**Re: Status of Improvement Permit Application: SFD2005-0015  
79 Morrison Drive Dunn, NC 27505**

An attempt was made to evaluate your property for the purpose of issuing an Improvement Permit. The evaluation could not be completed for one or more of the following reasons.

SITE PLAN APPROVAL SFD  
 DISTRICT BA-20M USE SAx48  
 #BEDROOMS 3  
 5/4/2020  
 Zoning Administrator

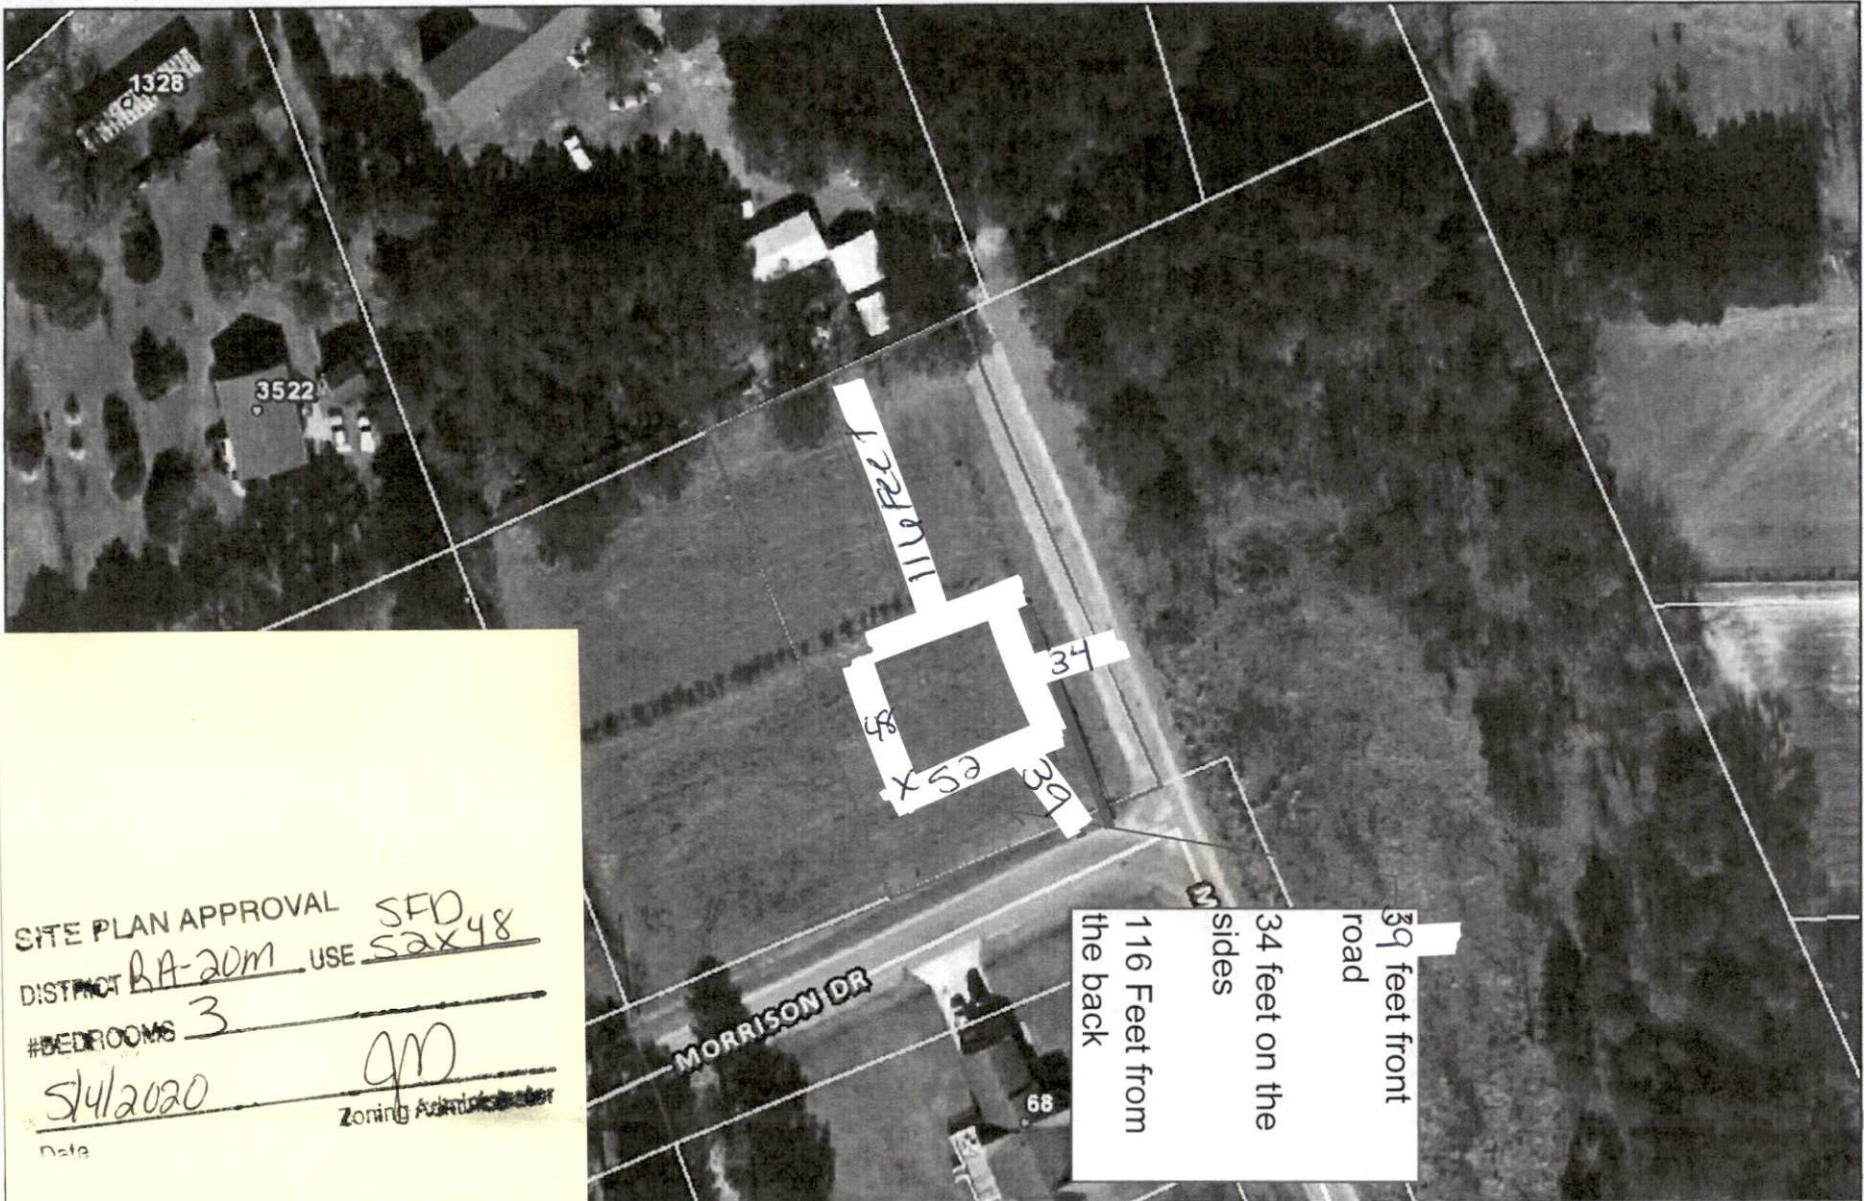
- 1. Use pink flags to mark property lines and irons that are set by surveyor need to be visible. (*\$25.00 fee incurred*)
- 2. Use orange flags to mark house corners (*\$25.00 fee incurred*)
- 3. Directions not clear to property (*\$25.00 fee incurred*)
- 4. Property needs only brush or vegetation removed
- 5. Driveway not shown on site plan
- 6. Backhoe pits required
- 7. Other- **Incorrect County Setbacks-Coordinate with Harnett County Zoning to ensure SFD meets county setbacks. SFD flagged approx. 16ft from front property iron. 35ft front setbacks minimum. All front property irons shall be located, uncovered, flagged and property lines marked. Site plan shall be revised to reflect correct setbacks.**
